PERMIT ID: 2013-00085

has permission to **Interior renovations for staff offices for TSA on second floor**

TSA Project: Portland Jet Port

Below is a question from the City of Portland Permitting Office concerning fire-rating status of two doors within the scope of work?

3A 2ND FLOOR PLAN
SCALE: 1/8" = 1'-0"

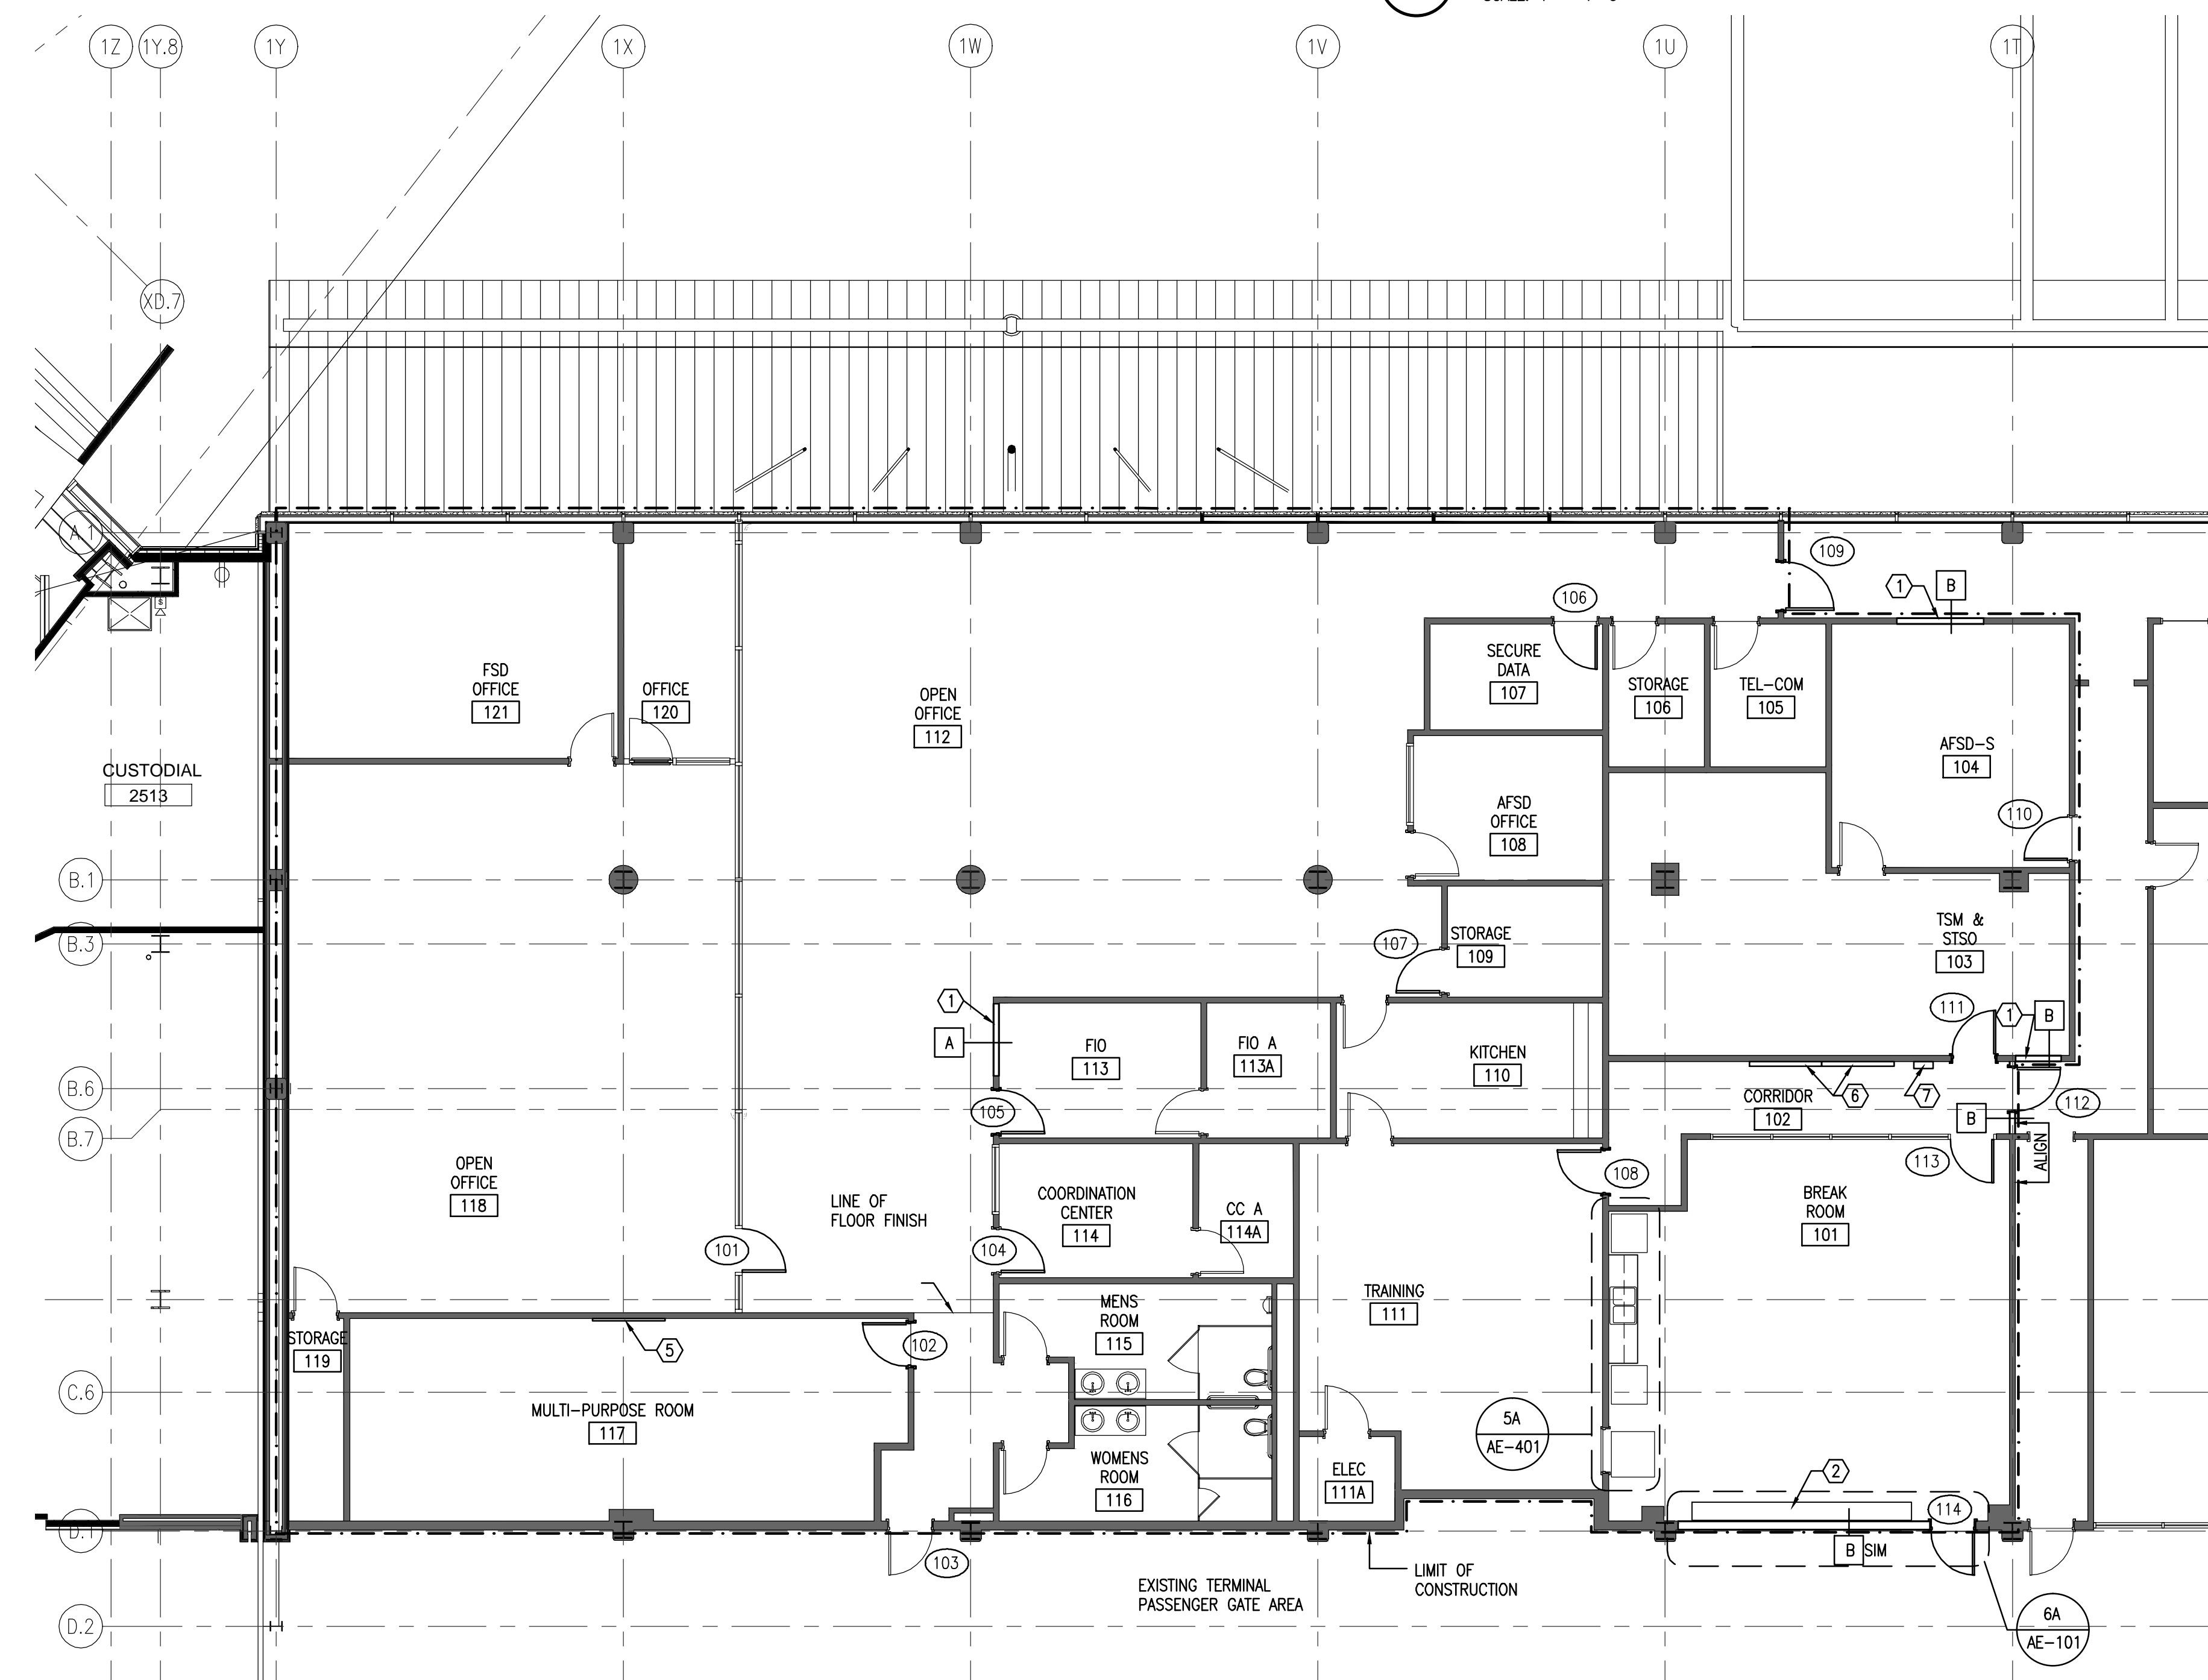
1. Plan AE1 01 specifies a 1 hour rated fire barrier per wall type B at the break room, terminal passenger gate area wall. Plan AE6 01, door schedule, doors #114 & 103 are not rated assemblies. Verify if the code analysis requires a fire barrier at this location and provide plan correction.

1. I, along with TSA personnel verified that door #103 is a fire rated door. This door will receive new security hardware and a new lock mechanism on existing door.
2. Door #114 is part of the Bid Option 2, if selected this door will be removed and the wall opening will be filled in completely.
 - 2a. If Bid Option 2 is **NOT** selected and they decide to install a new door #114 and frame **the door and frame do require a 20-minute fire rating.** NOTE: An addendum will need to include this fact since it is not noted on the IFC prints.

I talked with the A&E firm concerning your questions on the two doors within the project. Attached is the answers to your questions. The 103 door is fire rated, just overlooked. 114 is a aluminum framed window wall with door. Bid Option 2 if accepted will remove the door and remaining glass wall and a Type B wall will be installed.
